**KIRKLEES METROPOLITAN COUNCIL
INVESTMENT & REGENERATION SERVICE**

DELEGATED DECISION TO DETERMINE PLANNING APPLICATIONS

Reference No:	2022/62/93192/W
Site Address:	Empire House, Lewisham Road, Slaithwaite, Huddersfield, HD7 5AL
Description:	Erection of detached communal room with glazed link (within a Conservation Area)
Recommending Officer:	Katie Chew

DECISION – Conditional Full Permission

Project Proposed Extension.	
Address Former Town Hall Lewisham Road Slaithwaite.	
Title Planning Drawing.	
Drawing number P 01 B.	Date Feb 2020.

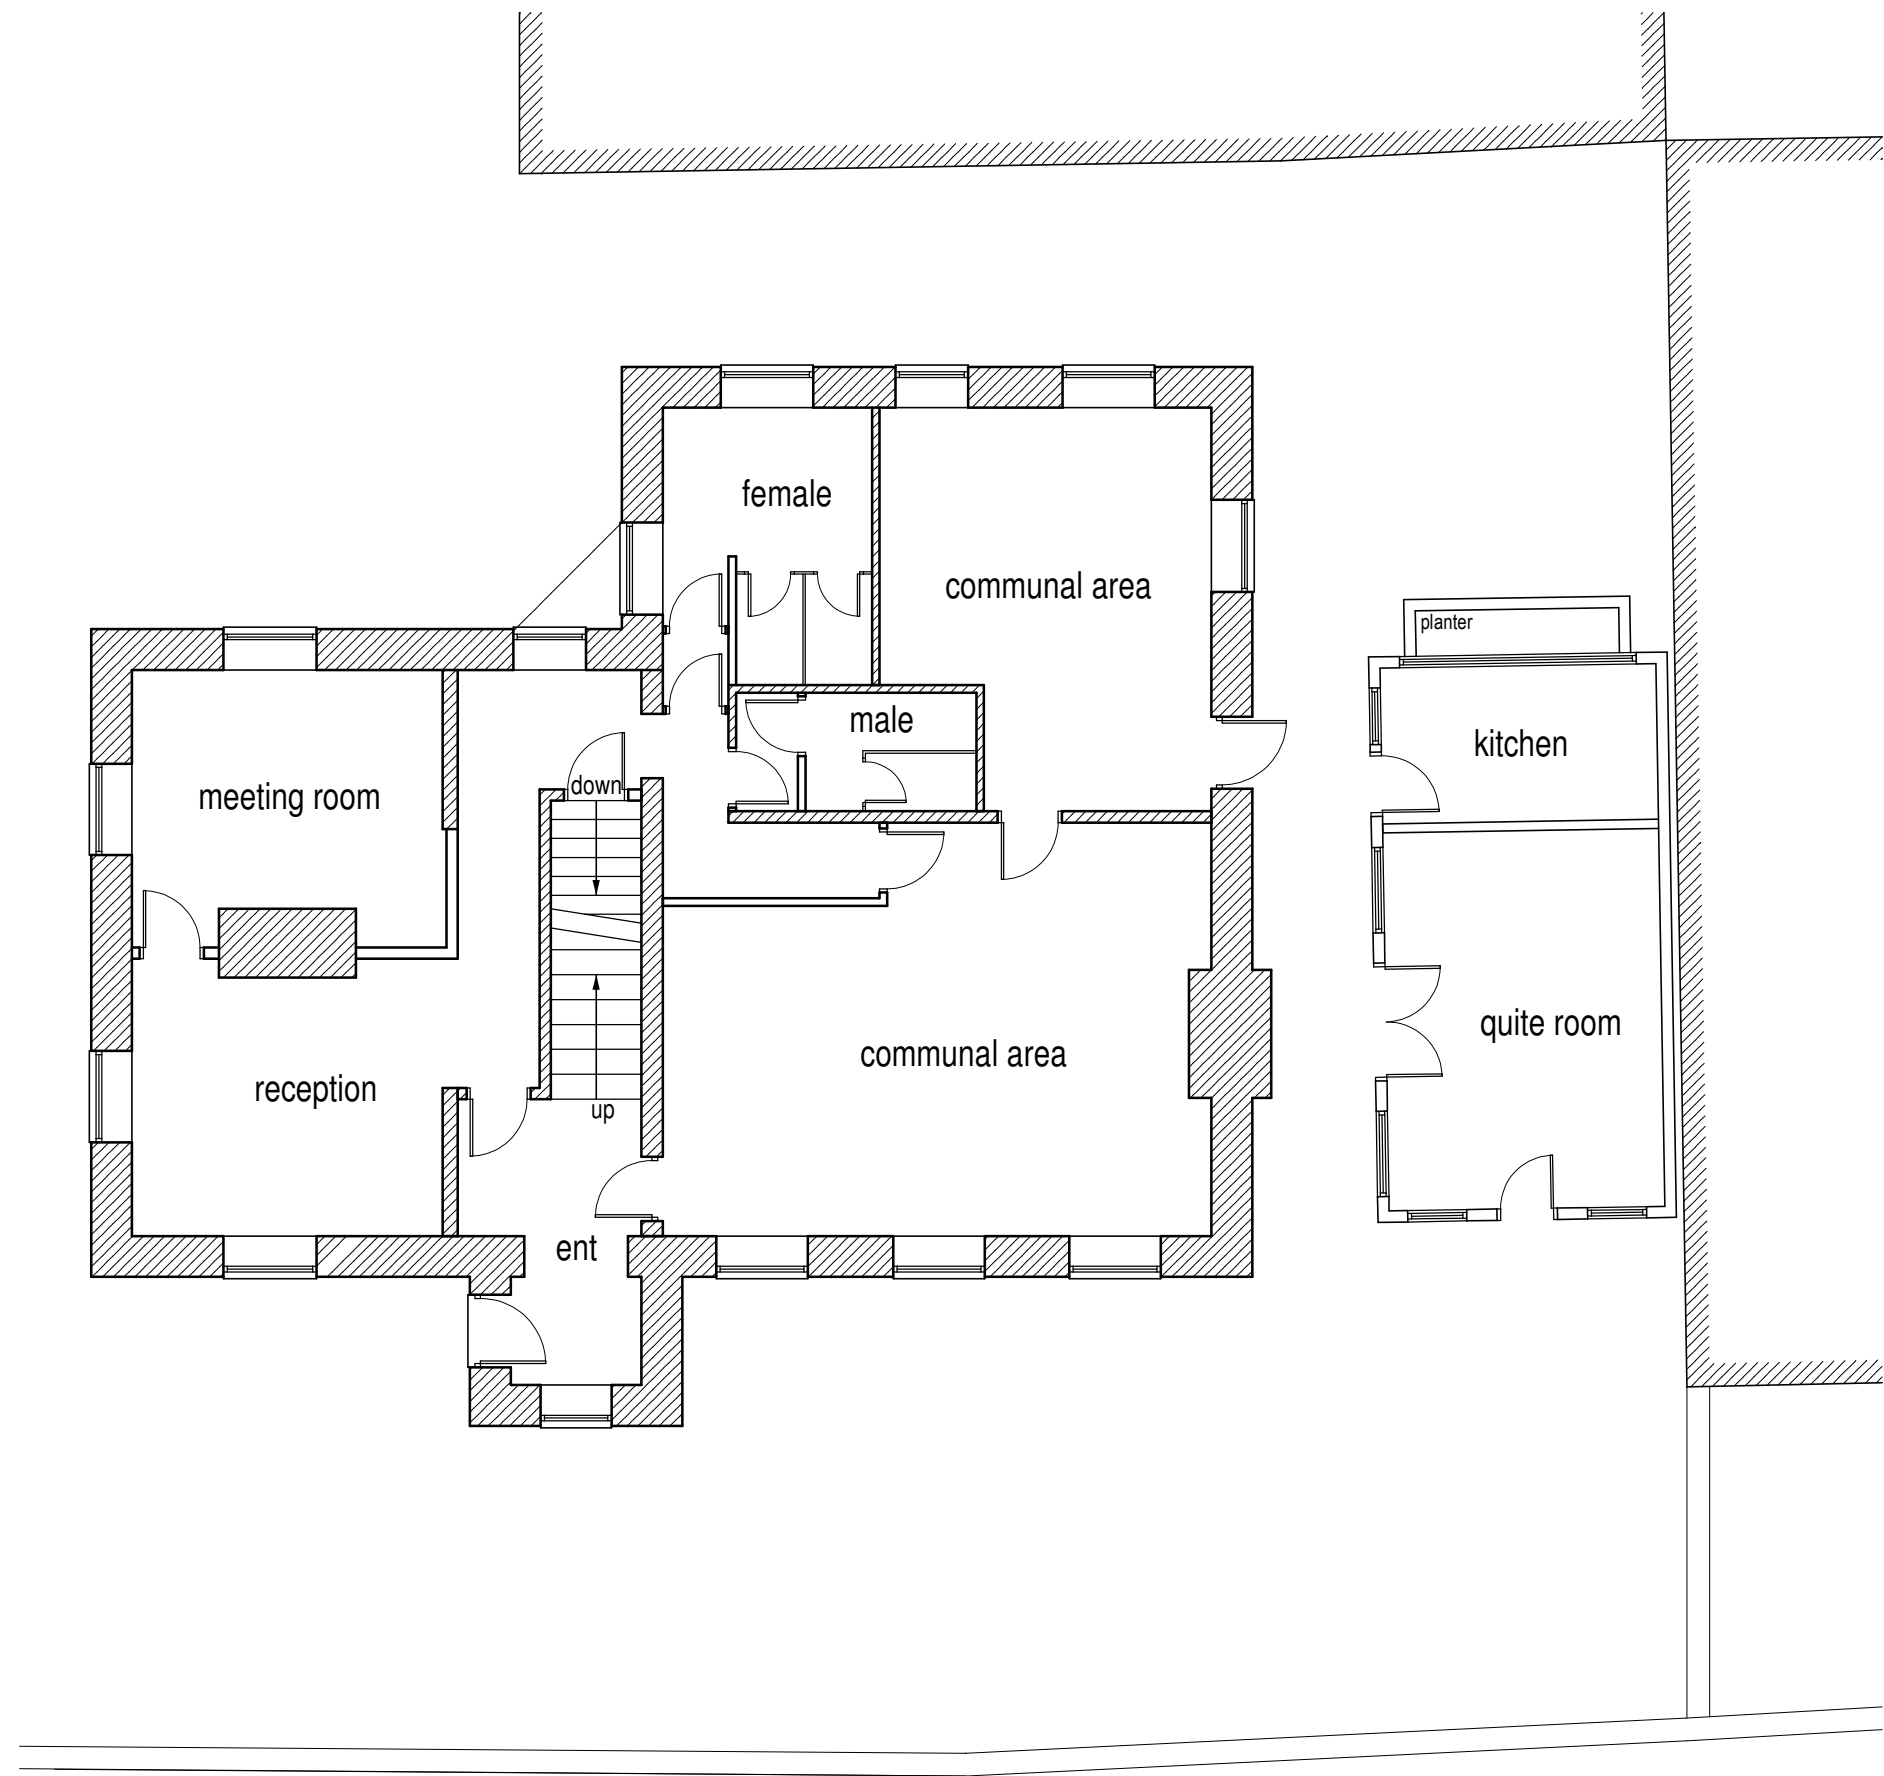
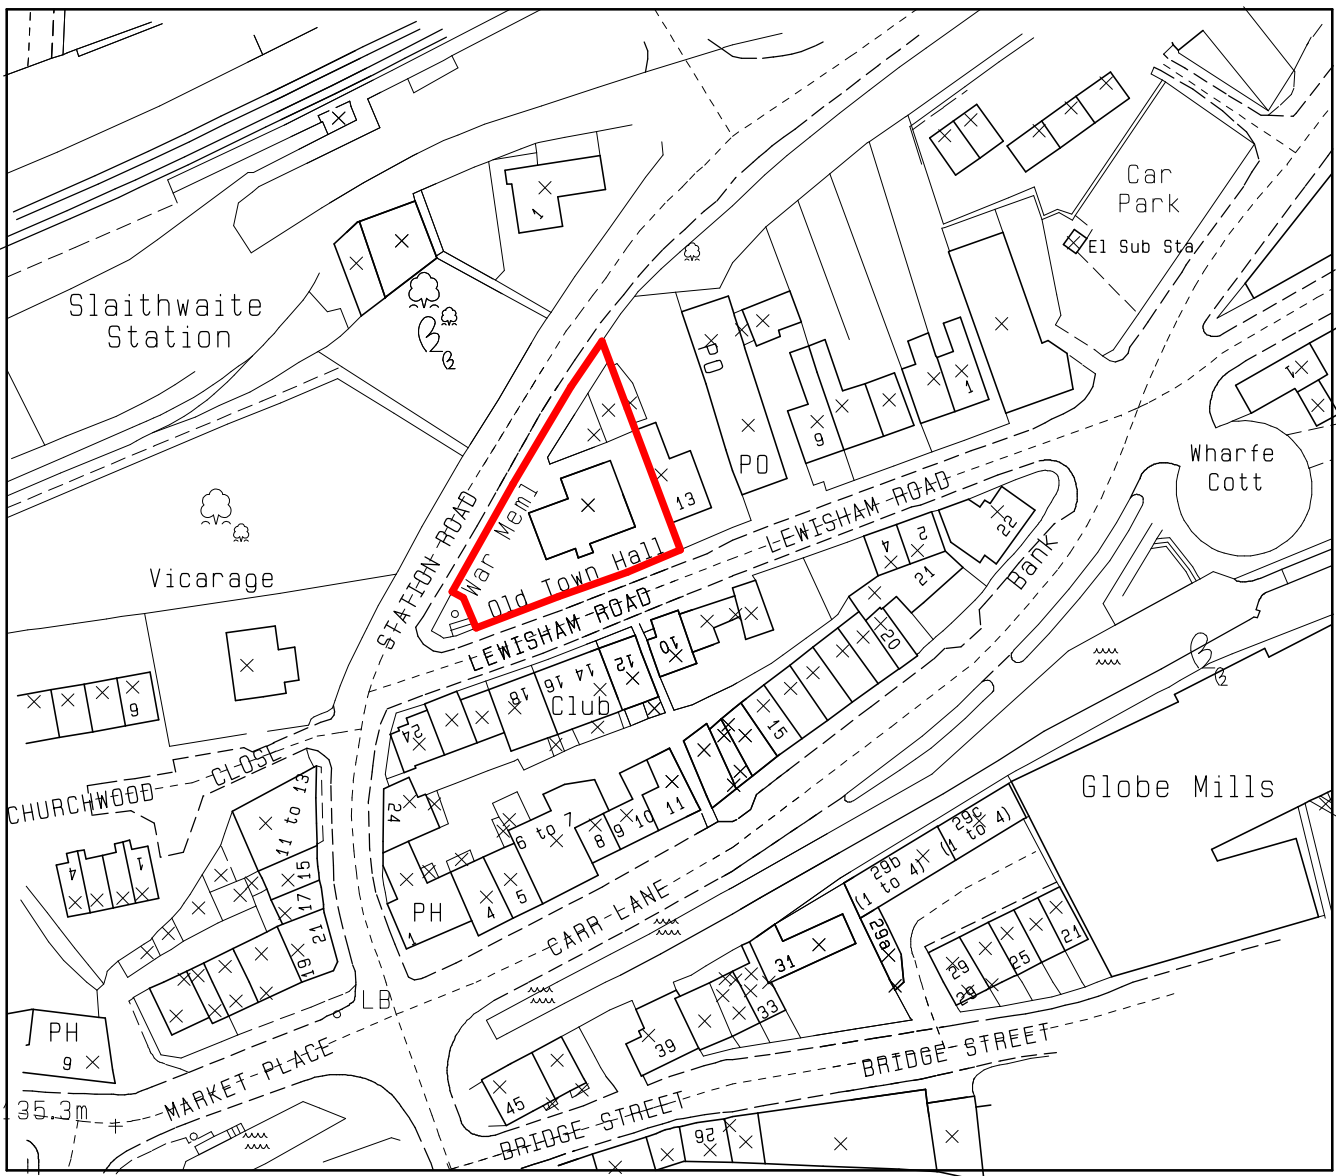
- The design of the building is not in keeping with anything else within the Conservation Area, nor being of any architectural merit in of itself it is visually out of place with the rest of the street and area as a whole.

- The building is visible from footpaths on both Station Road and Lewisham Road, two of the busiest roads in the area. Though foliage does cover the view of much of the building from Lewisham Road the main tree/s and shrubs are deciduous and lose their leaves in October/November time and do not leaf again until the end of April/May, leaving the building clearly visible from the footpath on Lewisham Road for 6 months of every year.

- Due to the height difference of the land and the placement of the windows at the front elevation of the 'quiet room' the front garden and entrance to the neighbouring property is easily overlooked from within the new building from all 3 windows, massively impacting on the privacy of the residents. Setting the building further back from its proposed sight and or installing frost/obscured glass would limit this invasion of privacy.

Officer note: Noted. The proposed design of the building is discussed in more detail within the visual amenity section of this report.

Officer note: Noted. This is discussed in more detail within the visual amenity section of this report.

Officer note: Noted. This is assessed in more detail within the residential amenity section of this report.

public domain. Whilst neighbour objections have been received which outline that the boundary planting is deciduous and that they lose their leaves in October/November time Officers consider that when taking into account the above assessment as a whole the development is deemed to be acceptable on balance, in respect of visual amenity.

The building outlined within this planning application is already constructed at the site and comprises of a painted timber frame located on a stone plinth. The building is considered to be of a somewhat light construction given its timber framing, single storey height, with flat roof design, and its limited footprint. Given this, and how far the building is set back into the site, it is considered that the building does not compete in prominence with the existing building and is be viewed as its own separate structure which is not considered to appear as a conspicuous feature in the street scene therefore not harm the significance of the conservation area.
